Addendum No. 1

RE: Contract # C204561

BRIDGE #13 OVER THE INTRACOASTAL WATERWAY ON NC-904.

The following revisions have been made to the Structure plans.

REVISIONS						SHEET NO.
NO.	BY:	DATE:	NO.	BY:	DATE:	S-13
1			3			TOTAL SHEETS
2			4			45

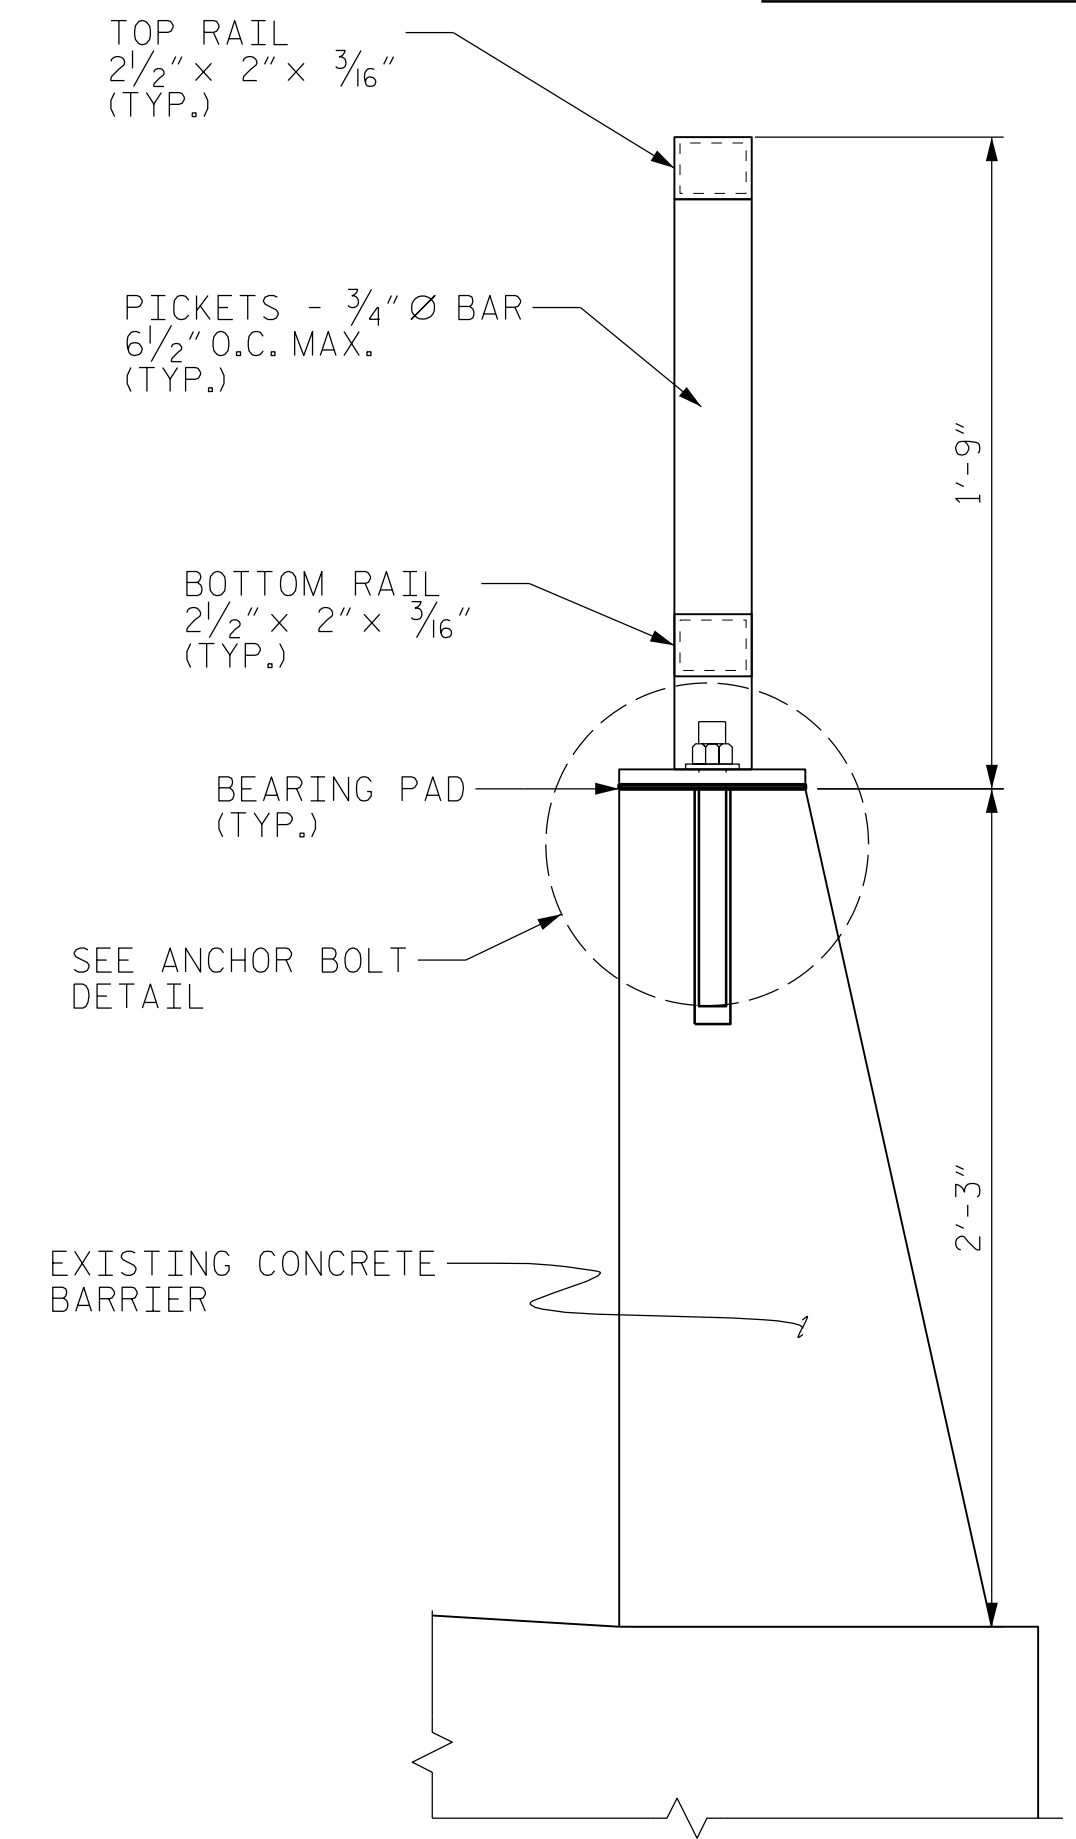
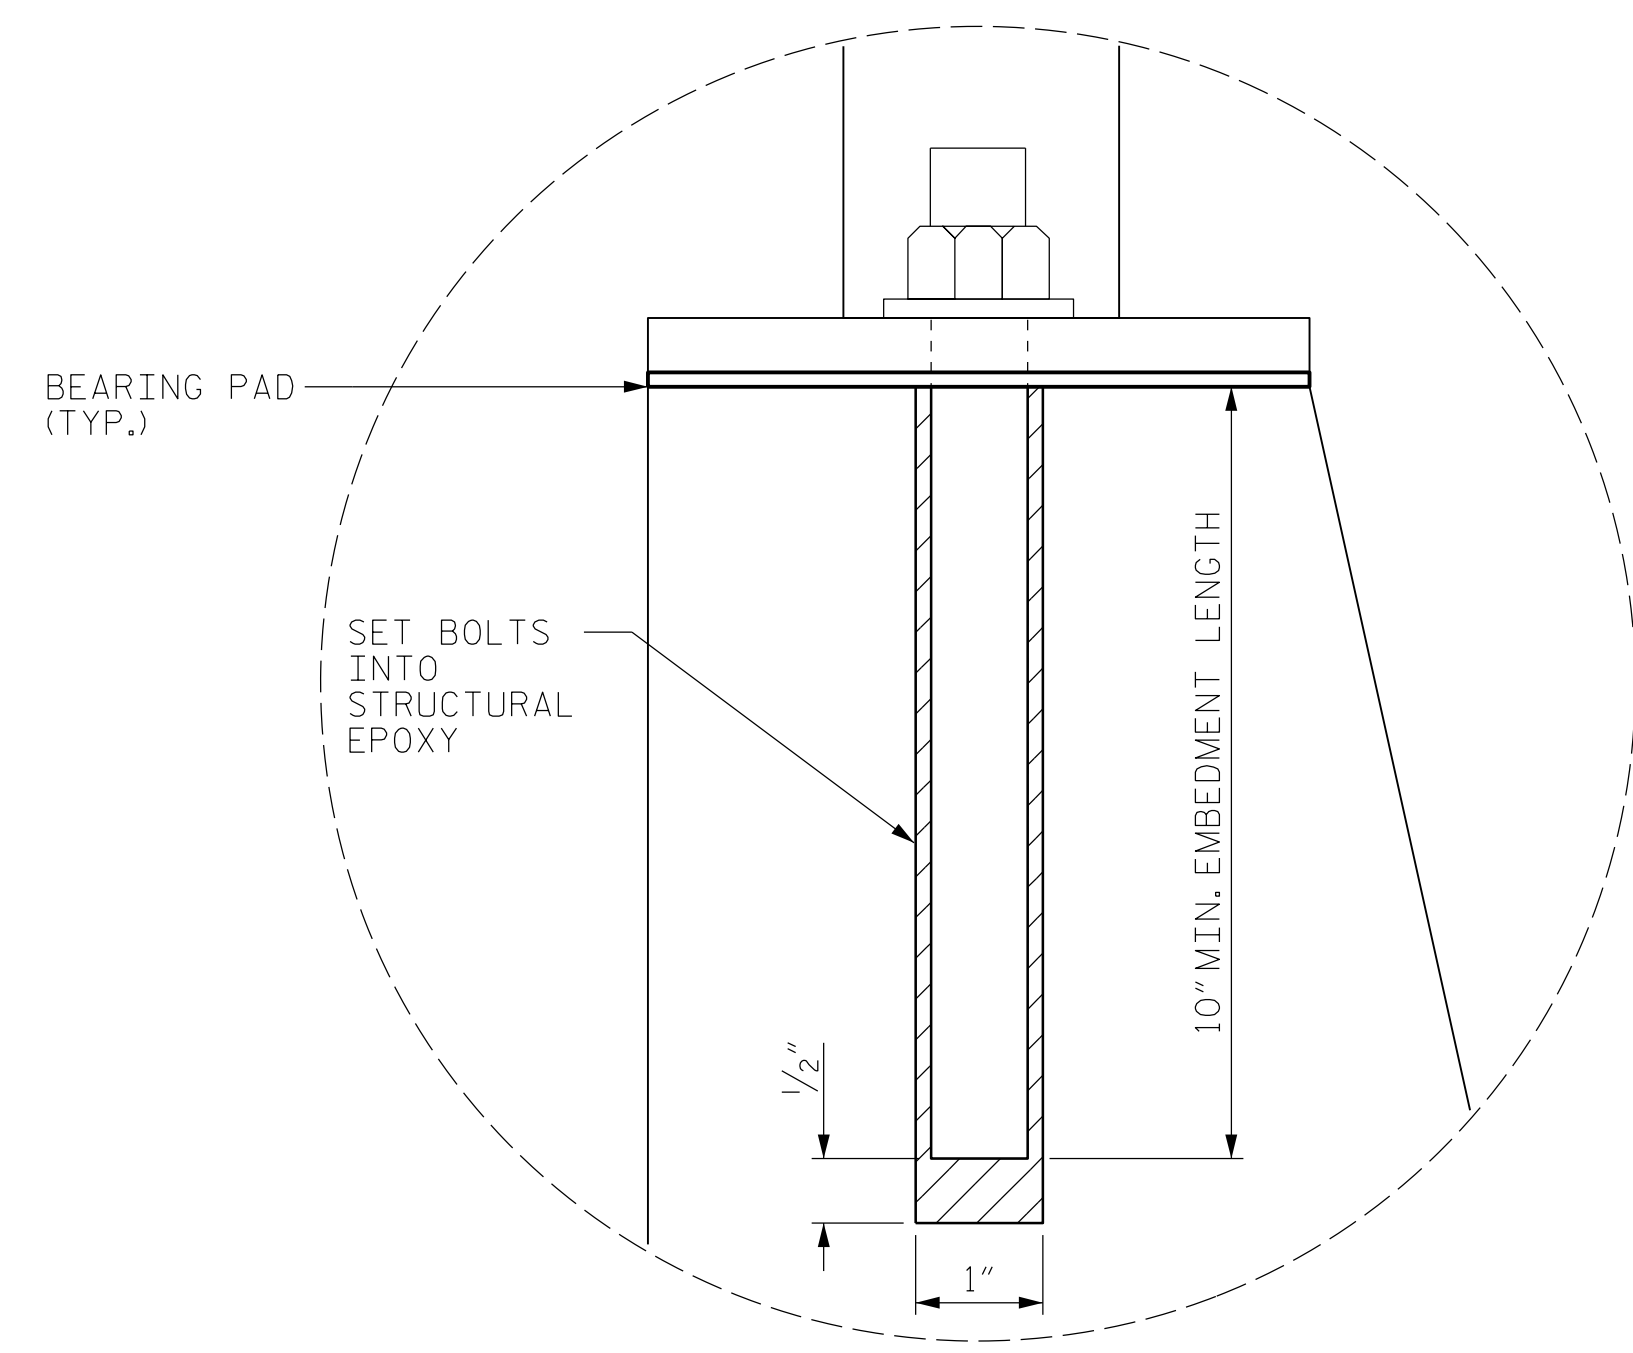
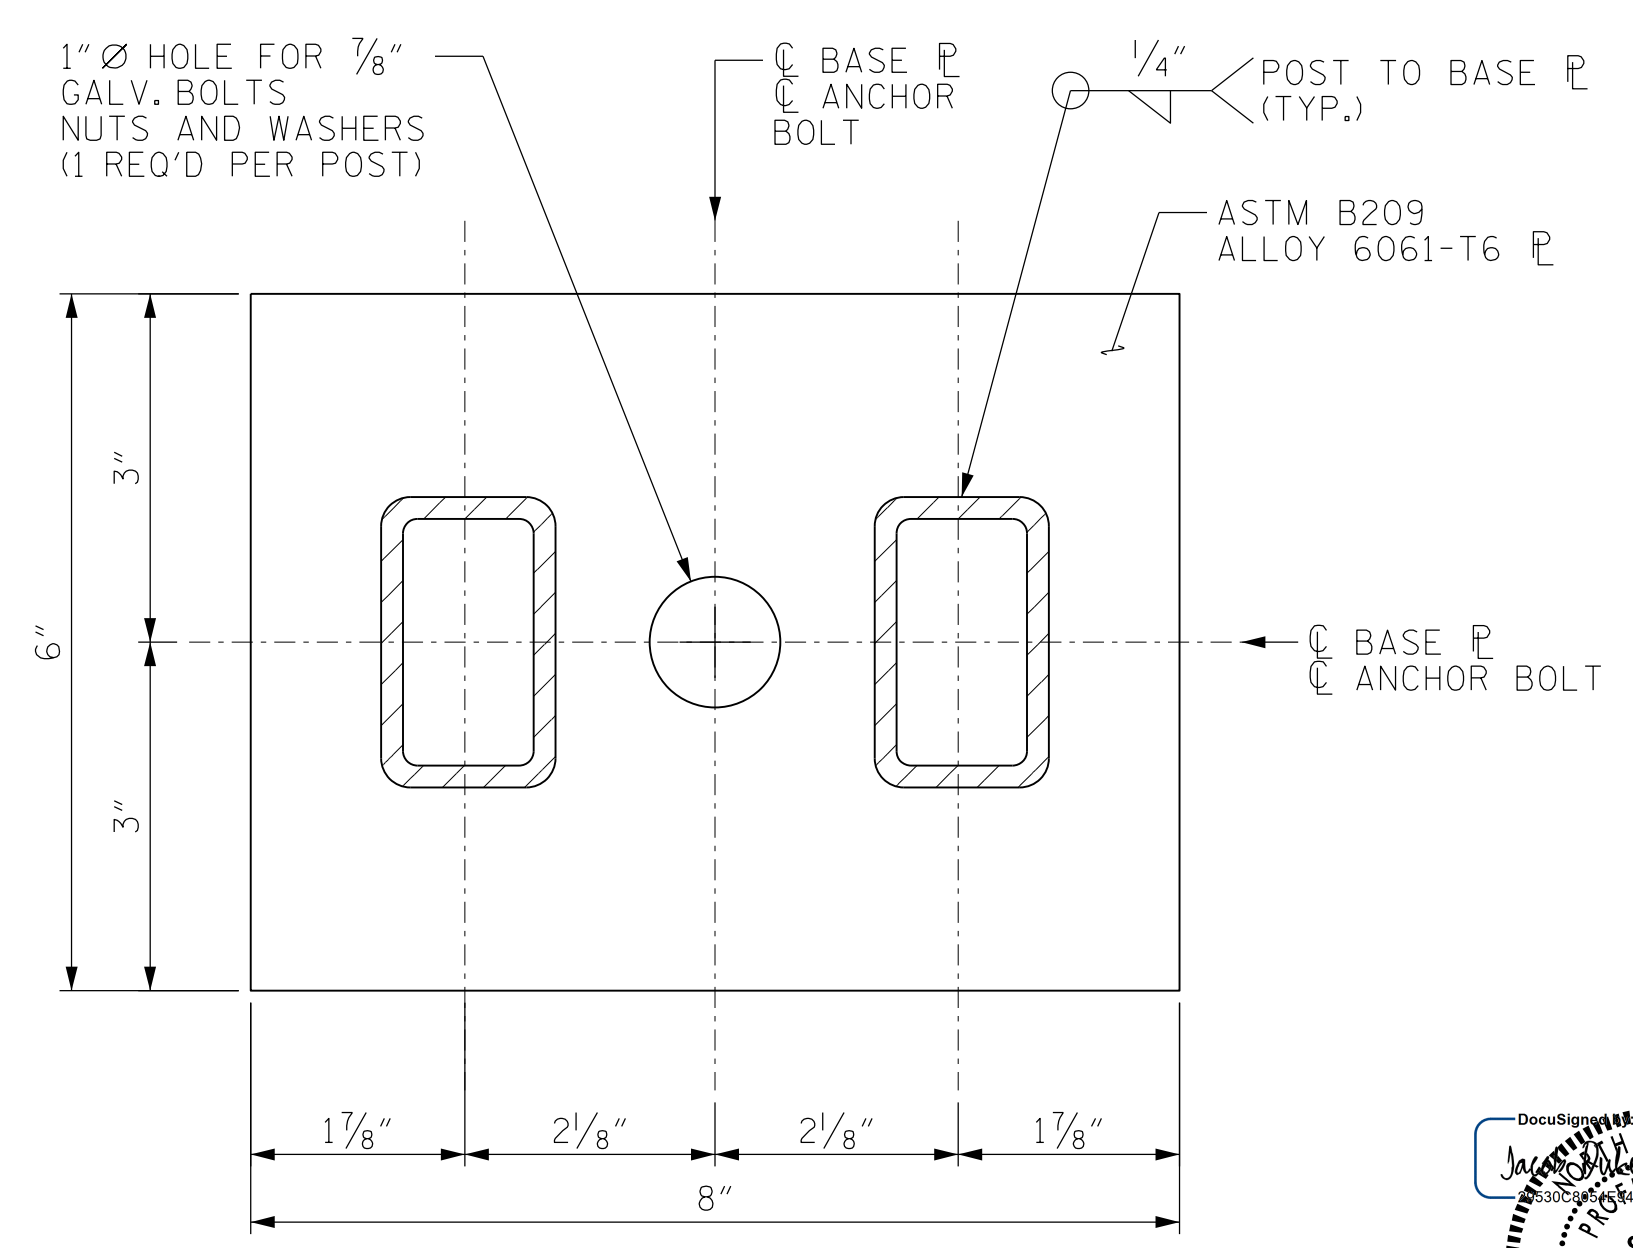
Sheet No.	Revision
1	Letting Date changed to December 15, 2020
S-1	References to "Early Strength" have been changed to "Very Early Strength"
S-2A	References to "Early Strength" have been changed to "Very Early Strength"
S-4	References to "Early Strength" have been changed to "Very Early Strength"
S-9	Note 7 and Note 8 have been added
S-13	Notes referencing stainless steel have been removed
